JBA Project Code2021s1635ContractSHD, Dundrum CMH, Dundrum, Co DublinClientLand Development AgencyPrepared byChris WasonSubjectStormwater Audit Stage 1 Report

1 Introduction

JBA Consulting have been contracted by Land Development Agency to undertake a Stage 1 SW Audit of the surface water drainage design prepared by Barrett Mahony Consulting Engineers (BMCE) for the proposed SHD at Dundrum Central Mental Hospital site, Dundrum, Co. Dublin. The surface water audit was undertaken in advance of a Strategic Housing Development (SHD) planning submission to An Bord Pleanála.

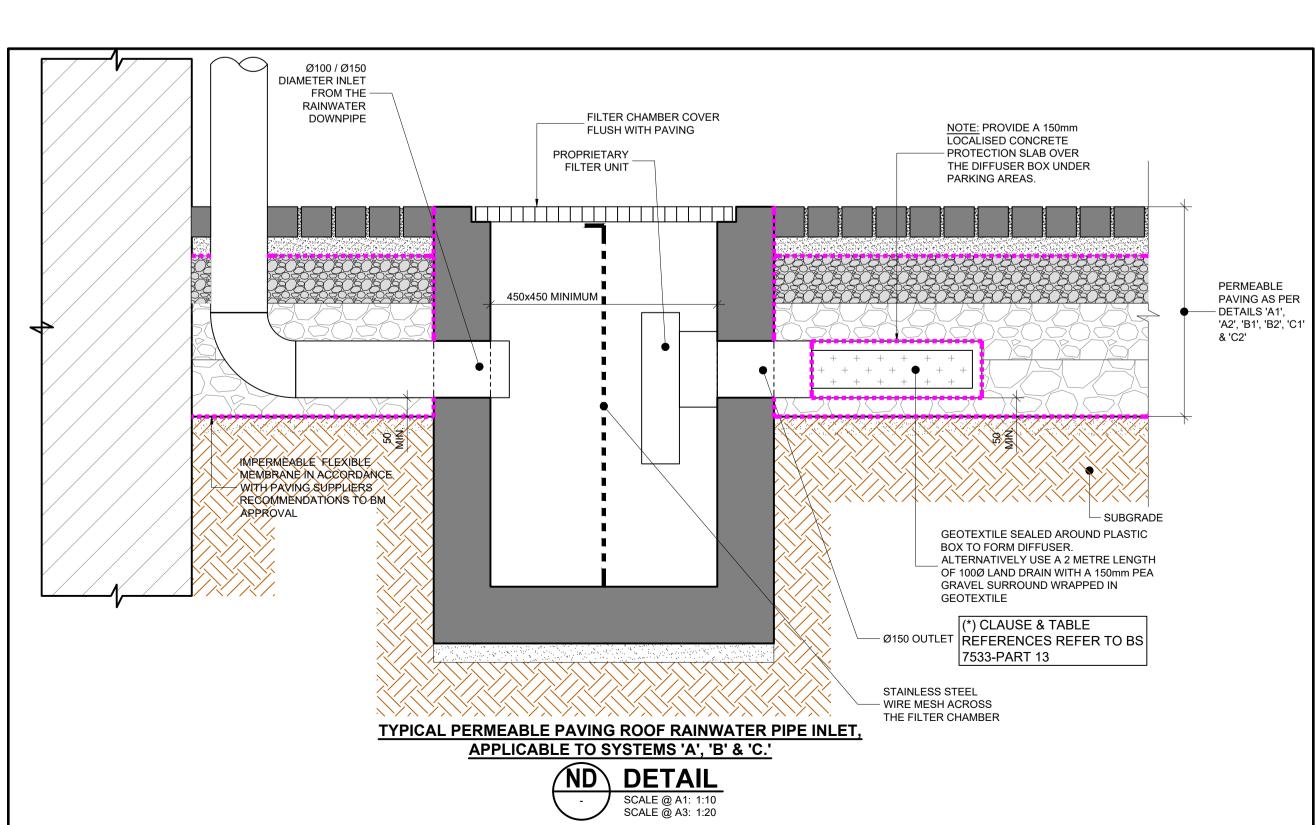
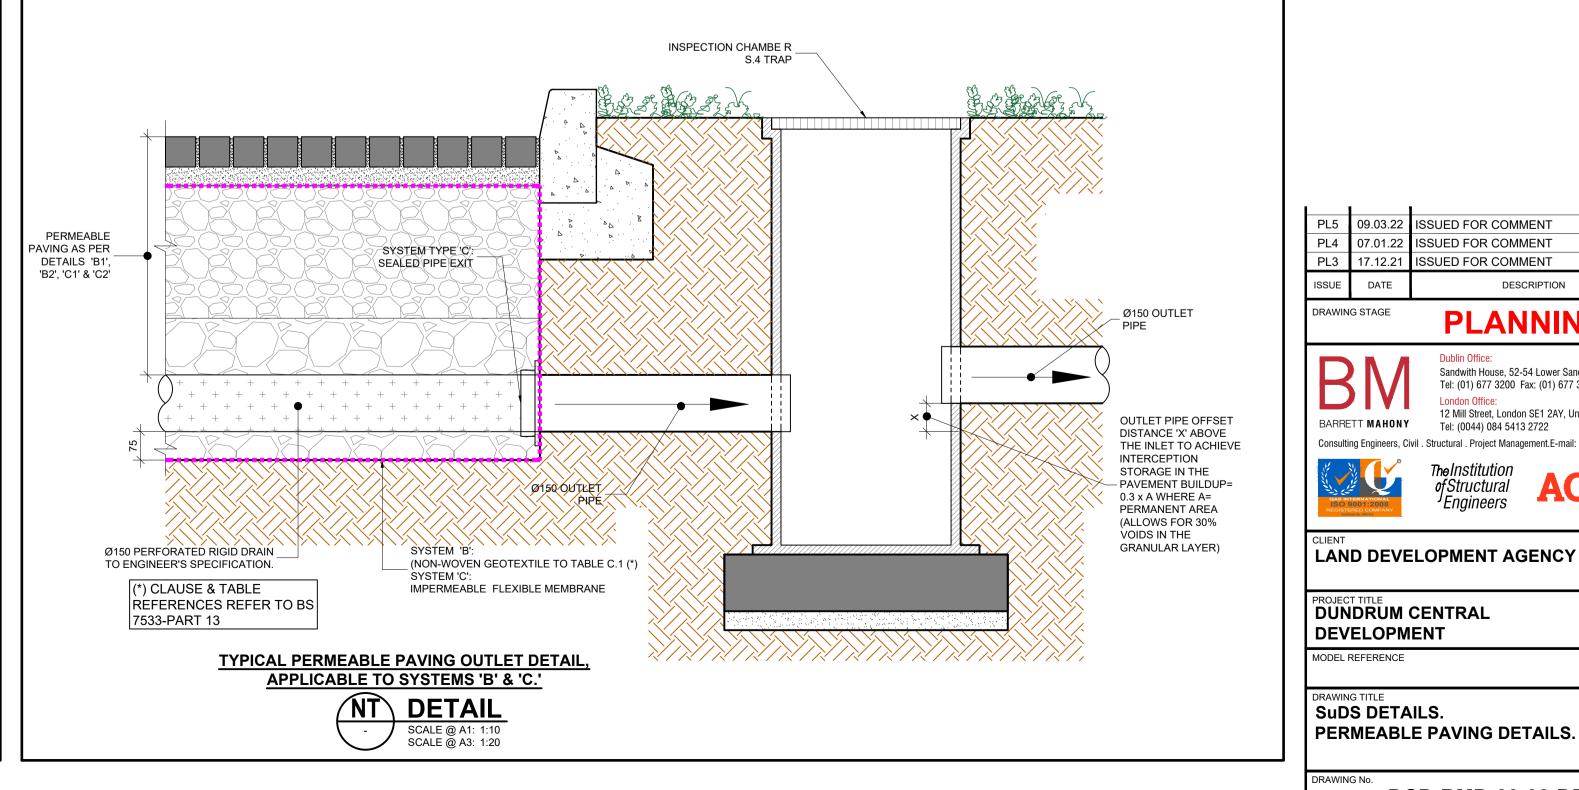
S2.3.4.4 refers to provision of a raised drainage pipe in the paving substrata by 100mm to give interception storage. It is queried if there is no infiltration if this could be provided. Also, the typical detail provided shows a land drain below the pavement substrata.

BMCE to justify their assumption that interception storage is provided in the undrained pavement substrata and amend the typical detail to suit if appropriate.

- Tank G (S4.7) has a volume of 260m3 in the Model but only 171m3 is indicated on the drawing.
- Drg 1205/PL4 provides typical details of permeable paving, both unlined and lined, but it is not clear whether the units proposed will be lined or unlined. The type to be adopted would make a difference in the assessment of interception as per Table 24.6 of the CIRIA manual.
